Please ask for: Nicola Moore
Email: nicola.moore@arun.gov.uk
Telephone: Ext 37944
Our Ref: WA/13/22/NMA
Your Ref:
Date: 17th February 2022

Application for a Non-Material Amendment Following a Grant of Planning Permission

Development: Non-material amendment following grant of WA/65/20/PL for the addition of opaque glass window 450mm x 450mm at 1100mm from the floor on east aspect of first floor of oak framed barn building and the addition of a standard external door on both east and west aspects of the same barn.

Location: Little Box Cottage Walberton Green Walberton BN18 0AT

EXISTING *Arundel*
GABLE ELEVATIONS

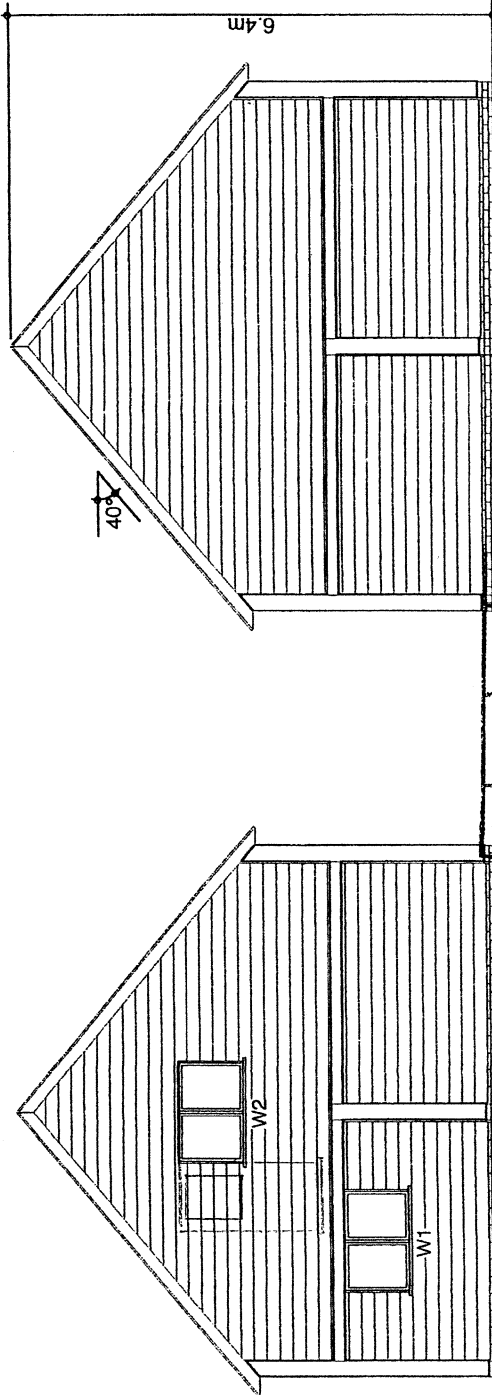
The submitted drawings are labelled Existing/Proposed Right Gable Elevation, but, show both Left and Right. Please check the labelling is correct, amend accordingly and re submit. Please also ensure any amendments are to the correct scale.

# PROPOSED FLOOR PLAN - FIRST FLOOR

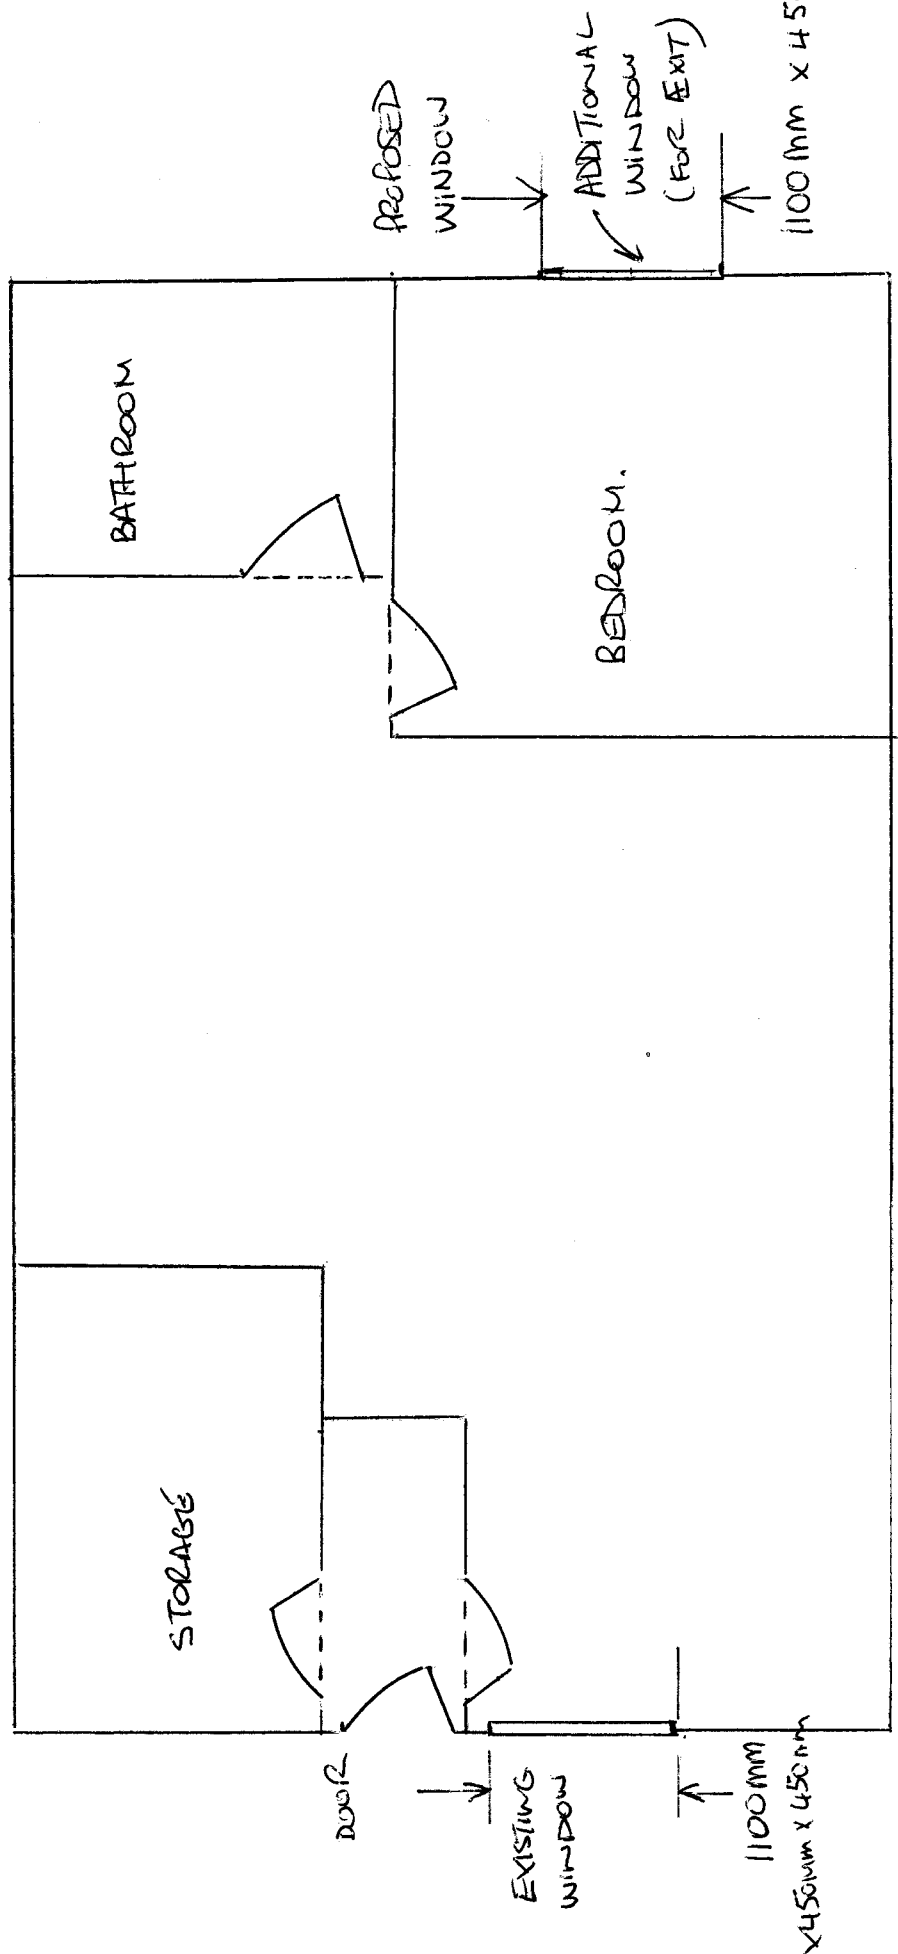
Please submit in PDF format floor plans at a scale of 1:50 or 1:100 clearly showing the proposed amendments.
